**WestConnex M4-M5 Link project (SSI 16\_7485)**

Thank you for the opportunity to further comment on the response to the issues raised by NSW Health following the EIA, the Preferred Infrastructure Report, and the Draft Consent Conditions for the WestConnex M4-M5 Link project (SSI 16\_7485). NSW Health provides the following comments for your consideration.

**Appendix A: Detailed comments from NSW Health's review of the Proponent's Responses to NSW Health's comments on the Environmental Impact Statement for the WestConnex M4-M5 Link project (SSI 16\_7485)**

## Appendix B: Detailed comments from NSW Health's review of the Proponent's **Preferred Infrastructure Report** for the WestConnex M4-M5 Link project (SSI 16\_7485)

Figure 2-1 Indicative White Bay civil site (C11) layout

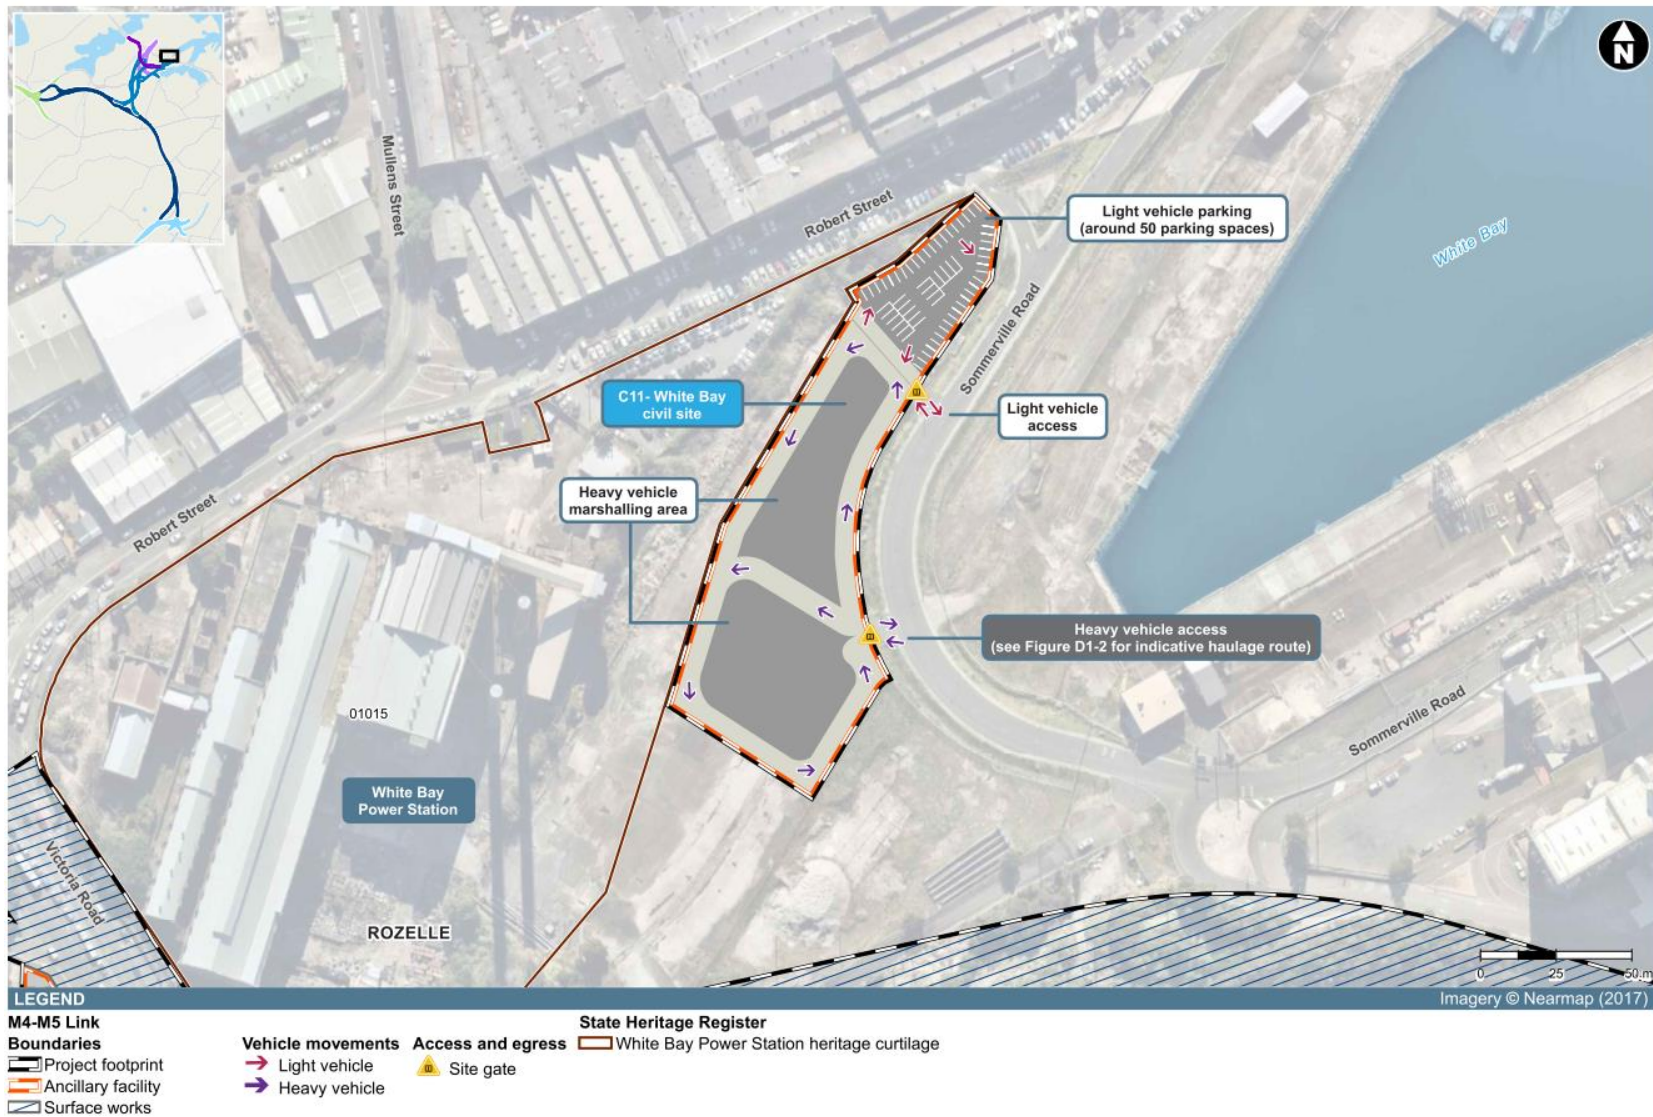
The inclusion of the White Bay Civil Site in the Preferred Infrastructure Report (The Report) will provide additional off street parking for construction workforce and be used for truck marshalling, resulting in the mitigation of a number of potential negative impacts on the broader inner west community from construction traffic related to the M4-M5 Link.

However, such use of the White Bay Civil Site may compound the impacts of the White Bay Cruise Terminal and other planned developments on the more localised community surrounding White Bay. The cumulative and consecutive impacts from various projects on the White Bay community should be mitigated and the specific mitigation techniques should be provided in the Report.

The potential for additional cumulative impacts including noise (such as trucks idling and reversing), air pollution, and amenity to the White Bay community should be minimised through ongoing and close liaison with the Ports Authority of NSW and Department of Planning and Environment (DPE). NSW Health is pleased that consultation has been undertaken with the Ports Authority of NSW, Urban Growth, and other stakeholders, and this is intended to continue throughout the life of the project and recommend this include specific consideration of the above issues related to White Bay Cruise Terminal.

The Report would be strengthened by quantifying the potential benefits from the reconfiguration of the White Bay Civil Site.

Best practice dust suppression techniques should be included in the White Bay Civil Site construction plan, and steps taken to ensure they are applied correctly to suppress any dust.

Figure 3-2 Approximate minimum working distances for vibration intensive works at the White Bay civil site (C11)

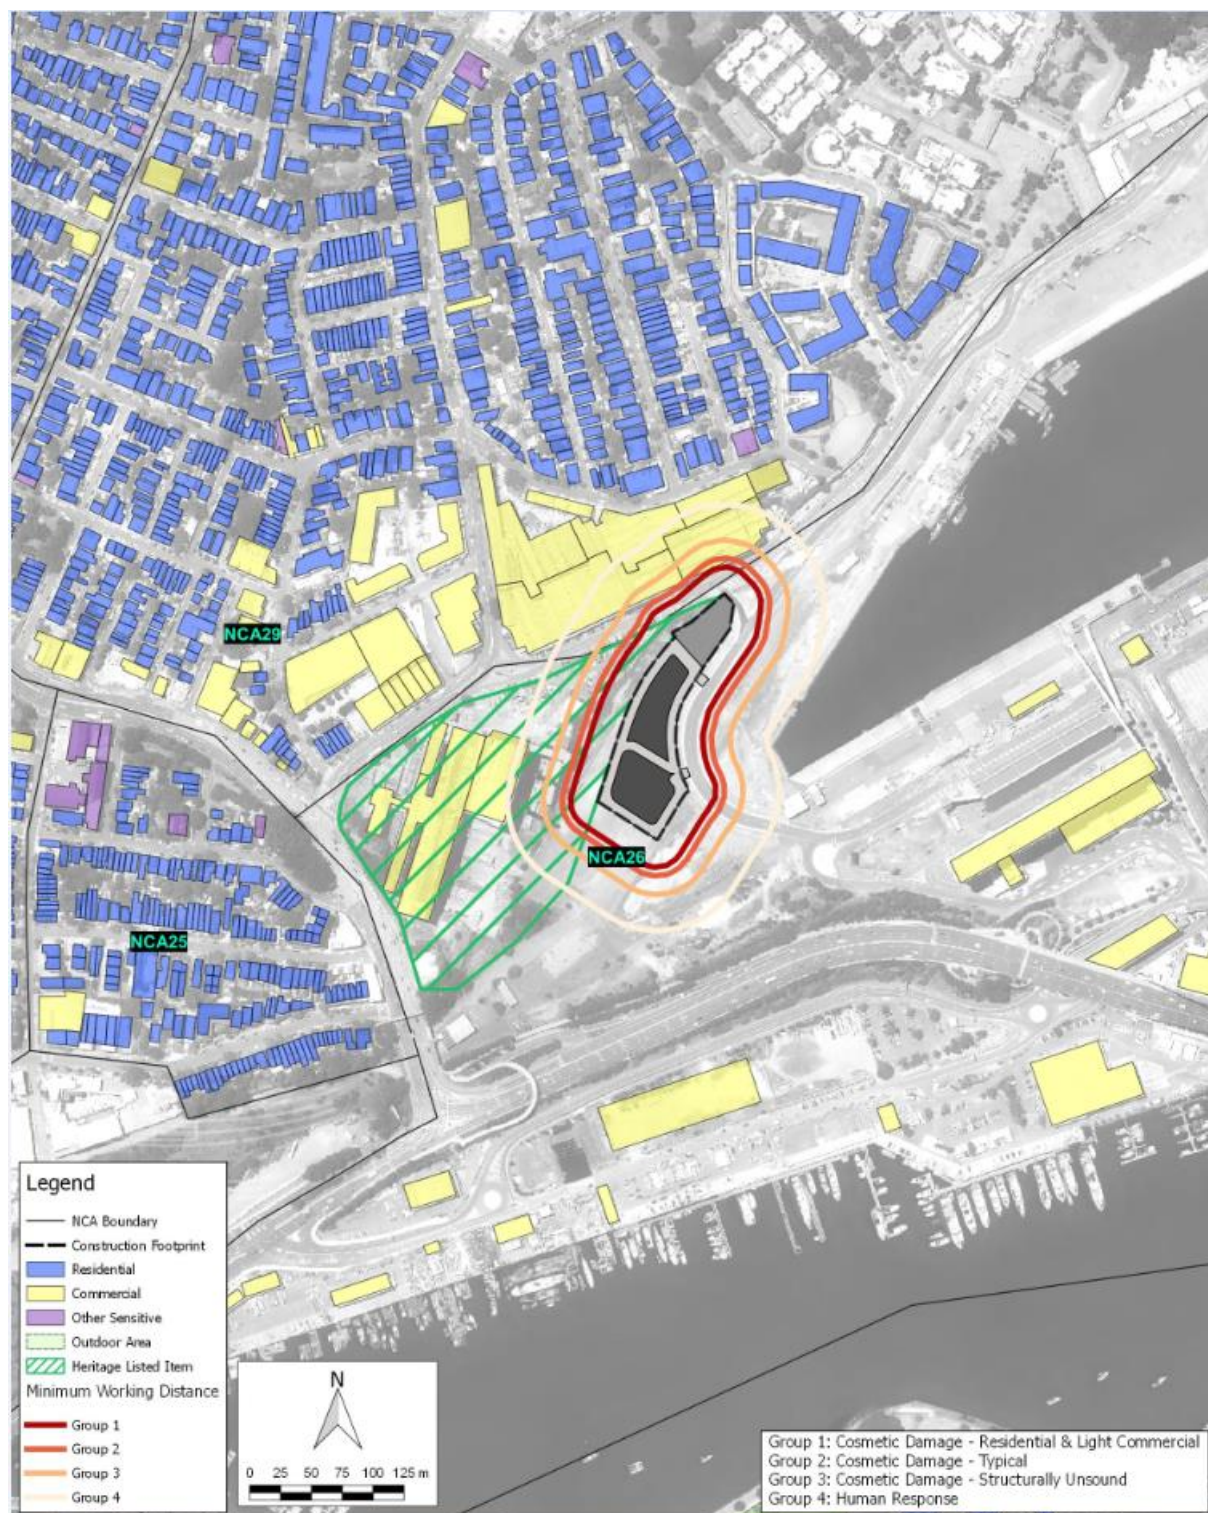
There is emerging evidence of adverse health outcomes from environmental noise, particularly related to sleep disturbance and cardiovascular disease. The report details a small number of residential properties along Batty Street and Mansfield Street that are projected to experience night time noise exceedances above the screening criteria for sleep disturbance. We suggest that the Construction Noise and Vibration Management Plan takes a strong focus on mitigation of noise at night time from construction works. This is particularly important considering the 3 year duration of the project.

NSW Health is pleased to see a clear proposal to use noise barriers as required (Table D2-27), and ongoing monitoring during the operation life of the site. As noise and vibration impacts are projects to affect some receivers, NSW Health recommends that all reasonable measures be considered to mitigate noise and vibration to these receivers during both construction and operation. Additionally, the independent acoustics advisor should play a central role in evaluating the effectiveness of these noise mitigation measures.
